## **WEST MIDLANDS INTERCHANGE**

### **WRITTEN REPRESENTATION**

drawing title  
ILLUSTRATIVE LANDSCAPE  
CROSS SECTIONS  
DOCUMENT 6.2 - FIGURE 12.12

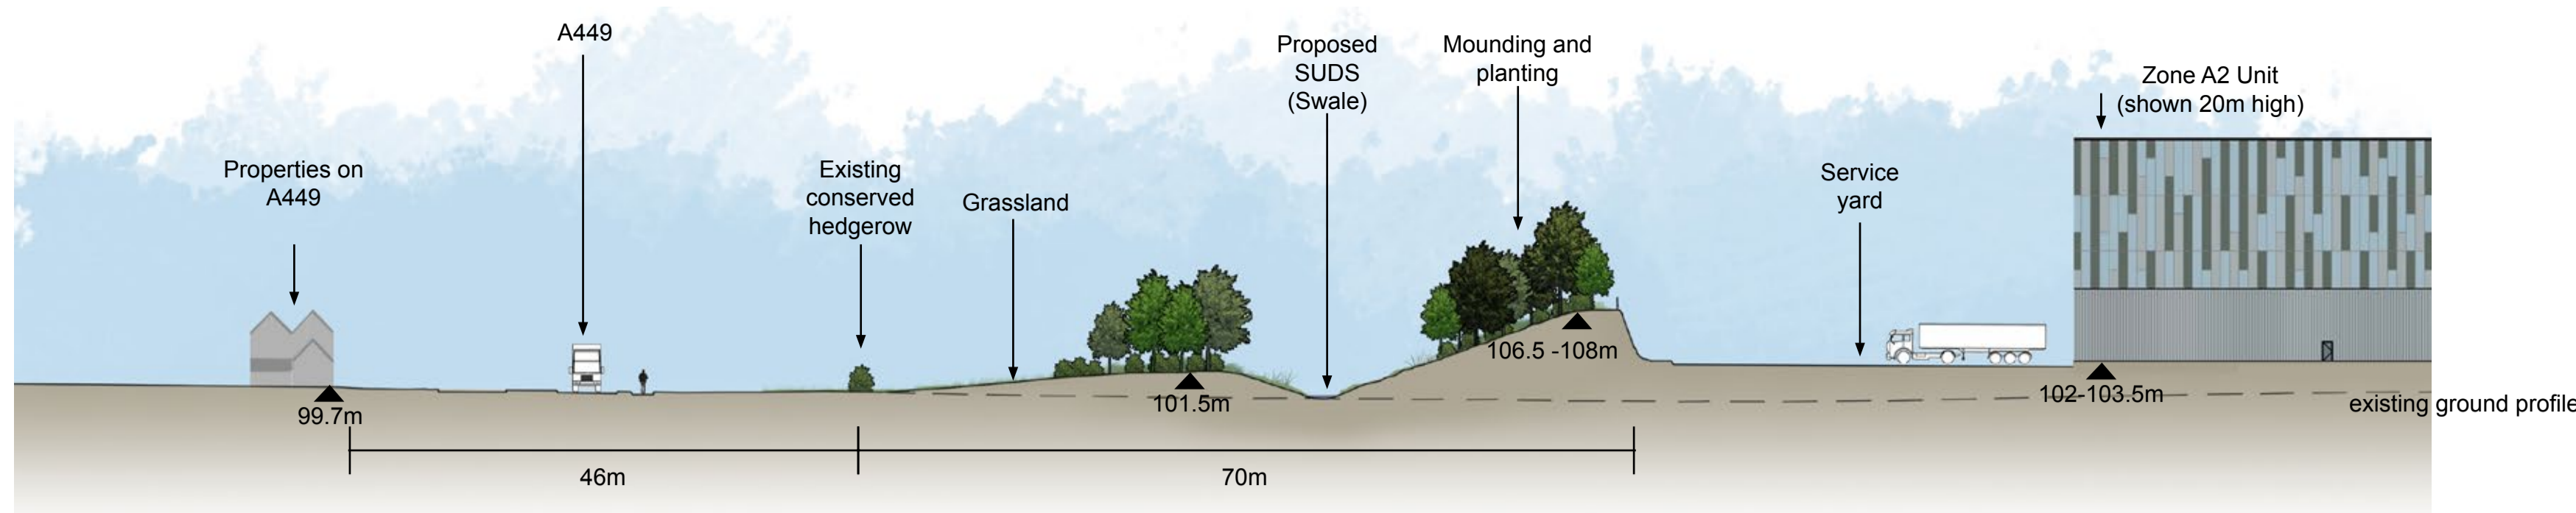
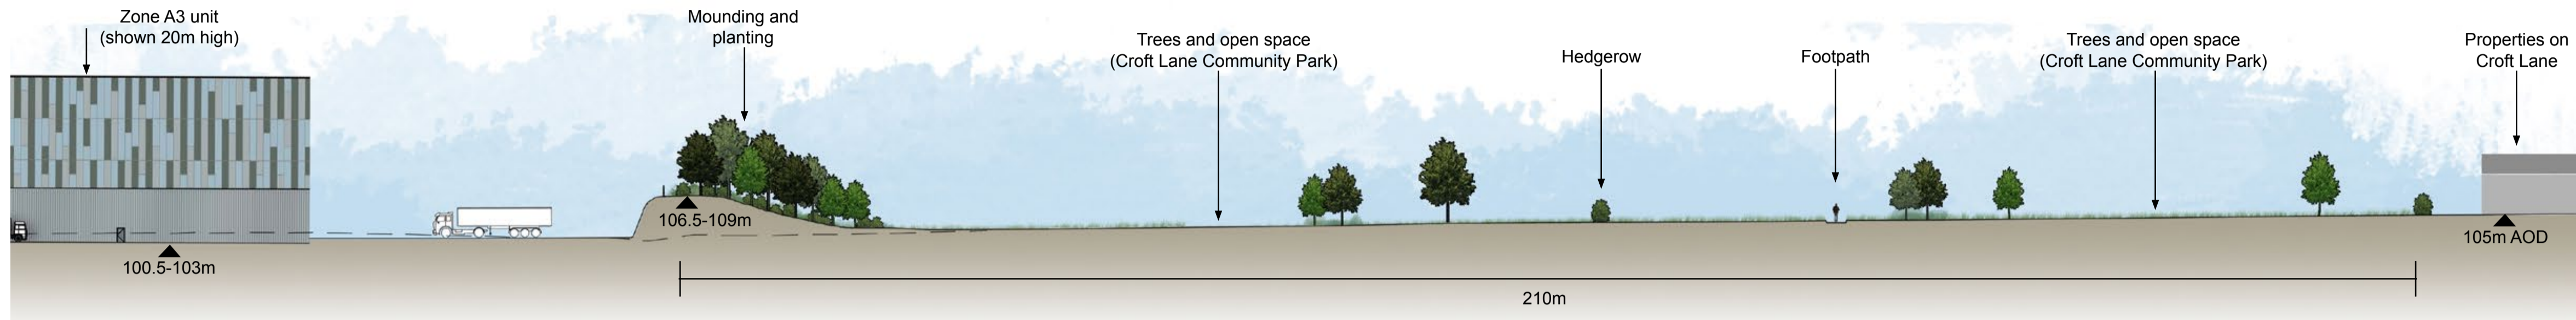
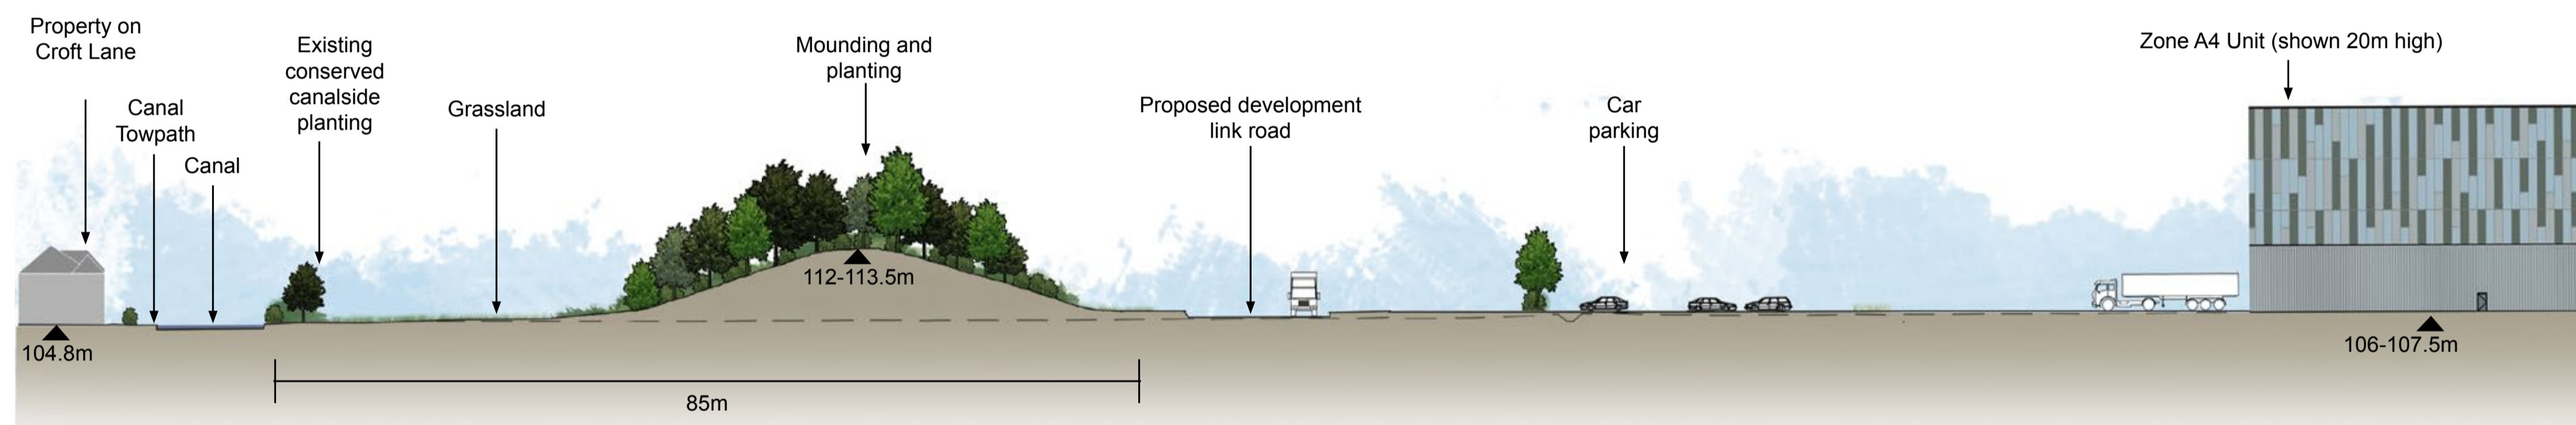
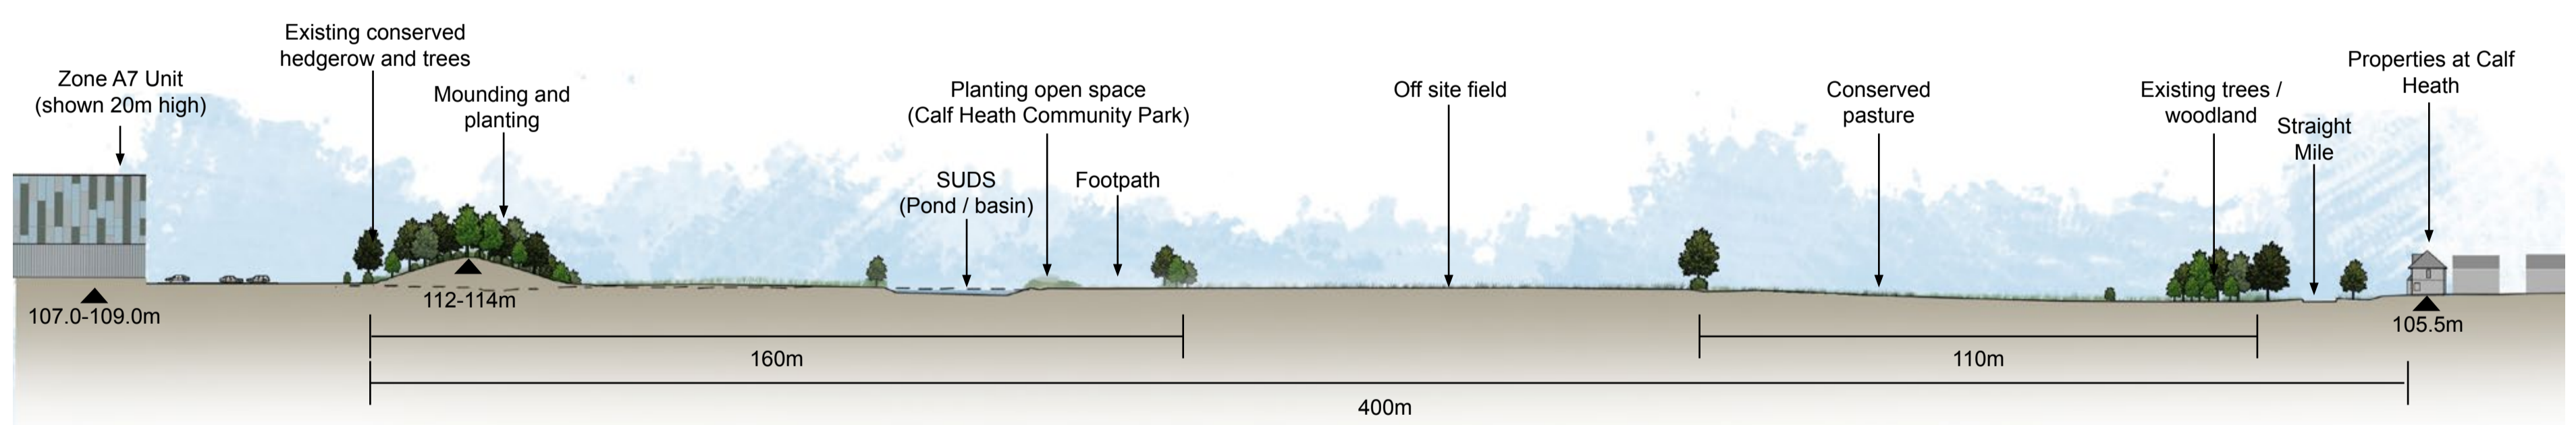
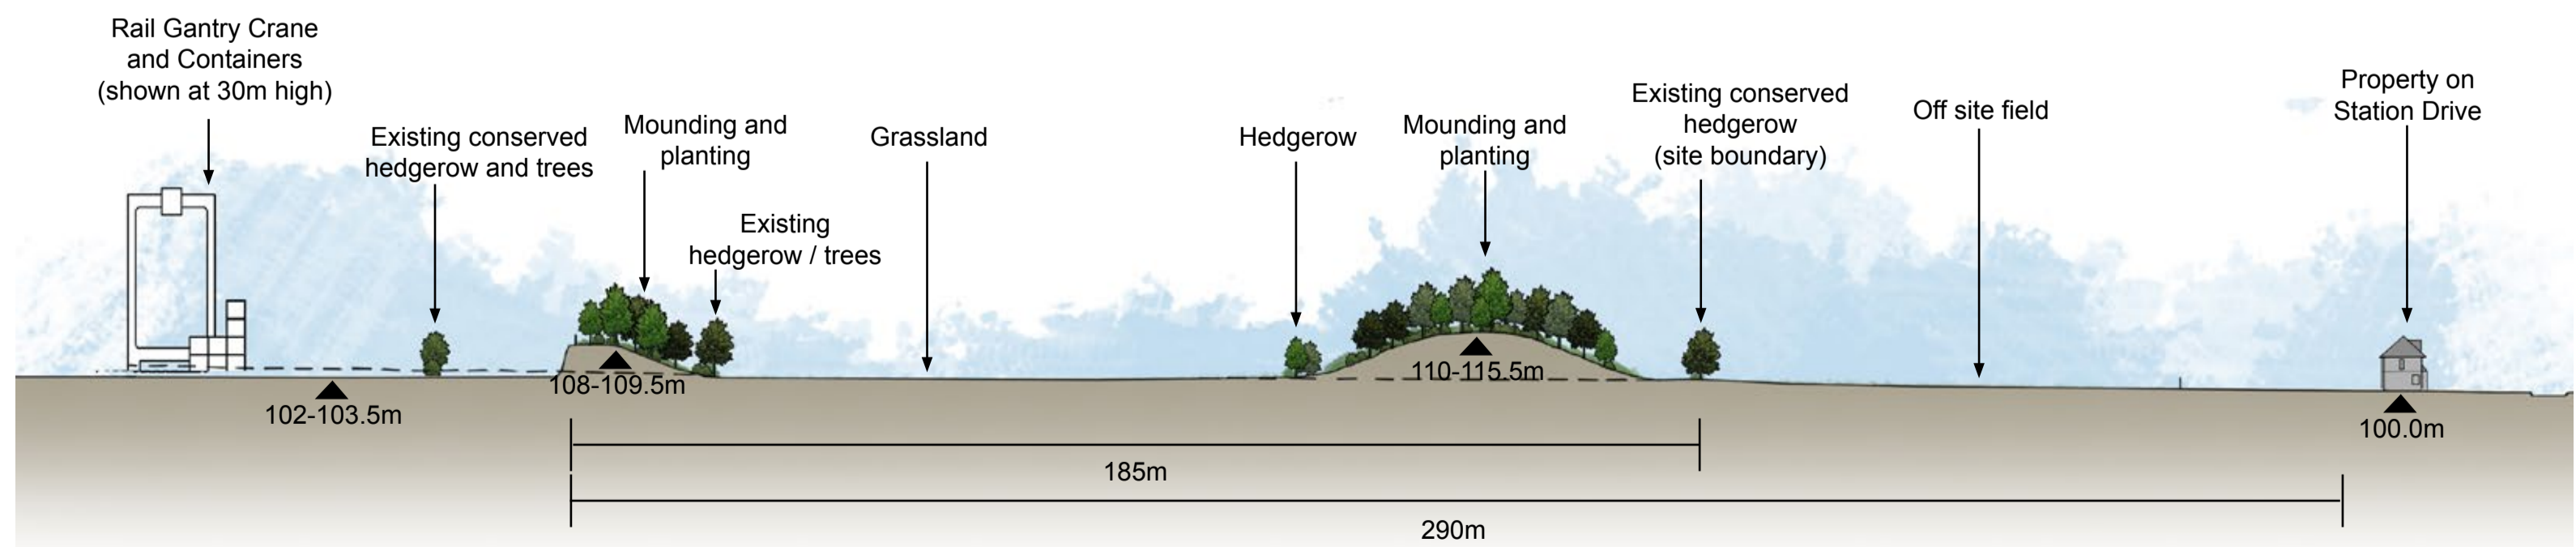
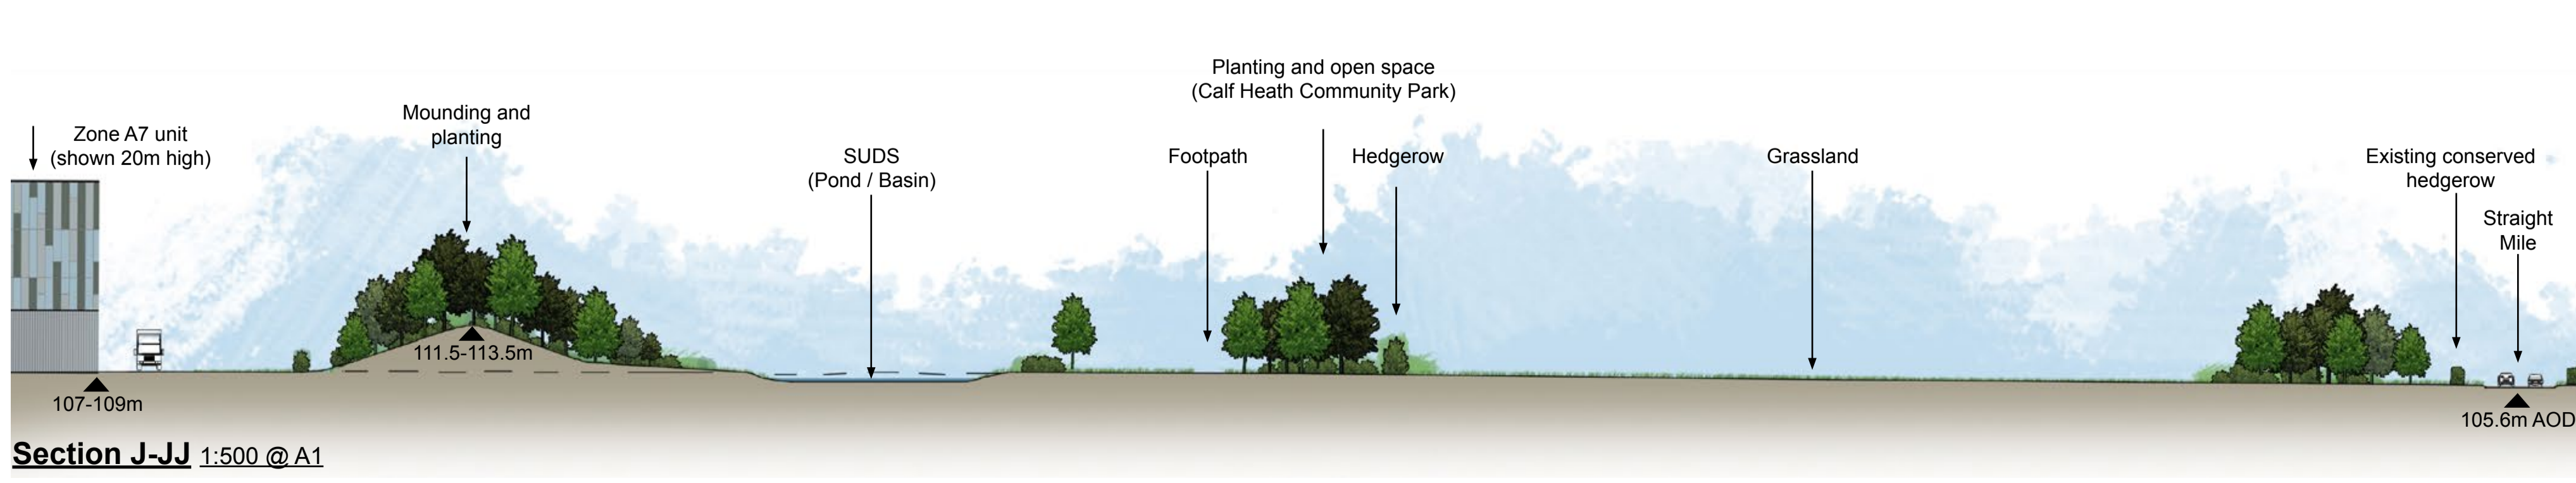
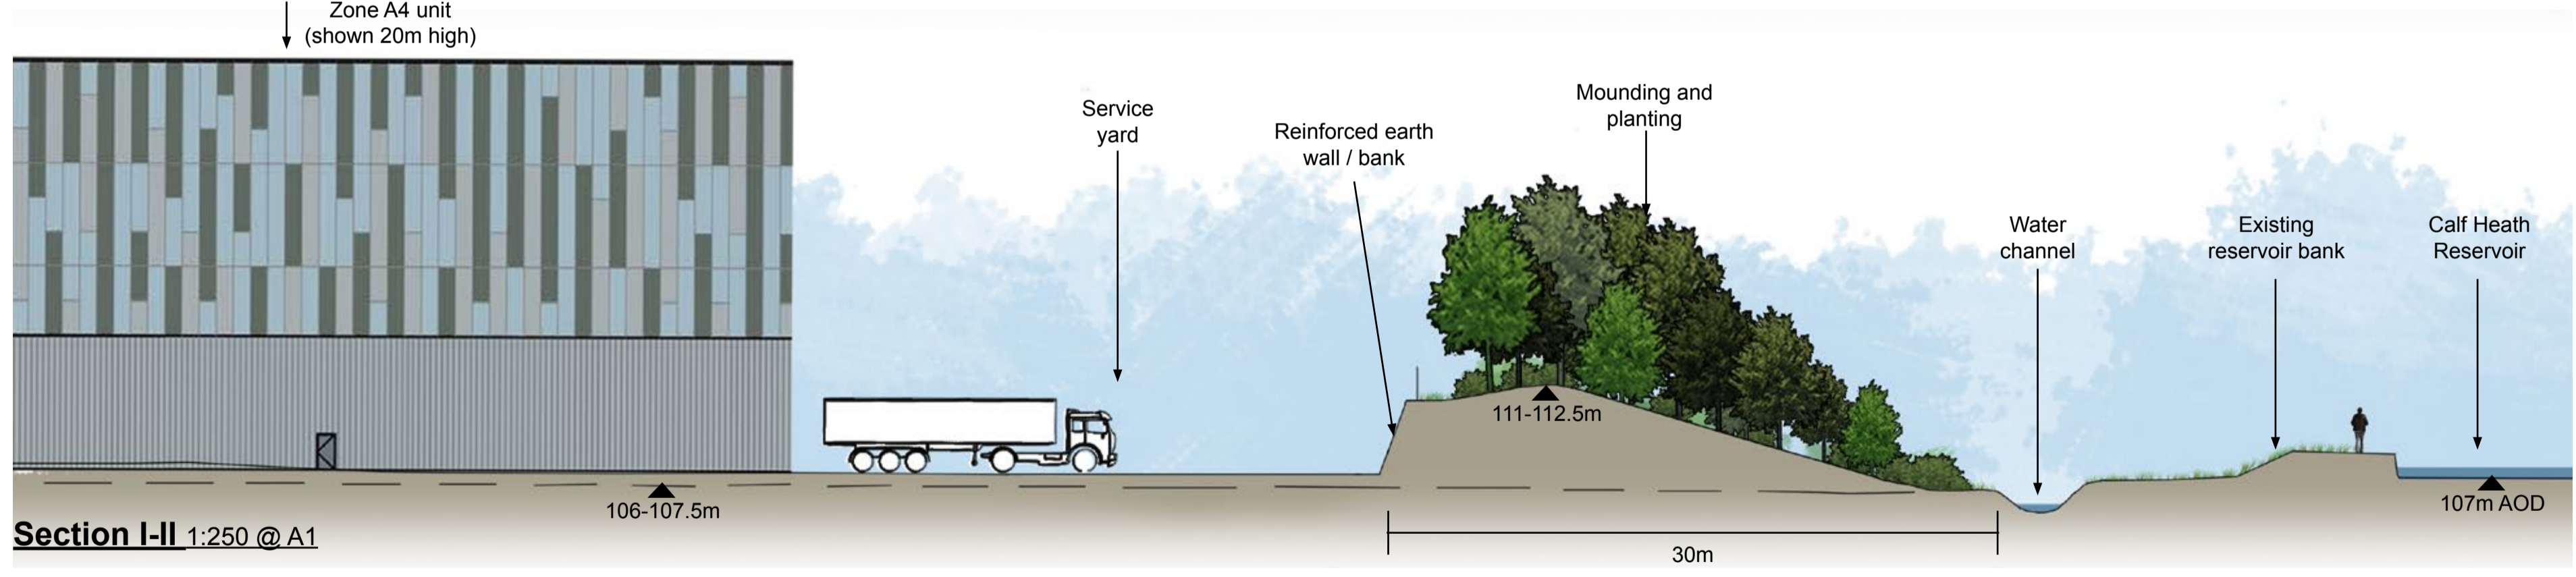
- 2.7. The County Council seeks clarity on the relationship of Finished Floor Levels (FFL) and bund heights relative to levels at the site boundary and surrounding landscape. During consultations with the developer, the Council has argued that the principle of reducing heights of development platforms and finished floor levels (FFL) would help to minimise landscape and visual impacts. Across the site FFL are consistently indicated considerably above existing ground levels and adjacent road levels. This is confirmed on the Illustrative Landscape Cross Sections. As the mounding height would be controlled by FFL it follows that relatively higher FFLs will increase building and mounding heights relative to the surrounding receptors. The County Council seeks clarity on the heights of mitigation bunds relative to adjacent levels outside of but in the immediate vicinity of the site. The Council believes there is further scope to enhance visual mitigation by limiting and reducing FFL heights; we seek a commitment from the developer to explore options to reduce the level of development platforms and FFL in order to minimise landscape and visual impacts.
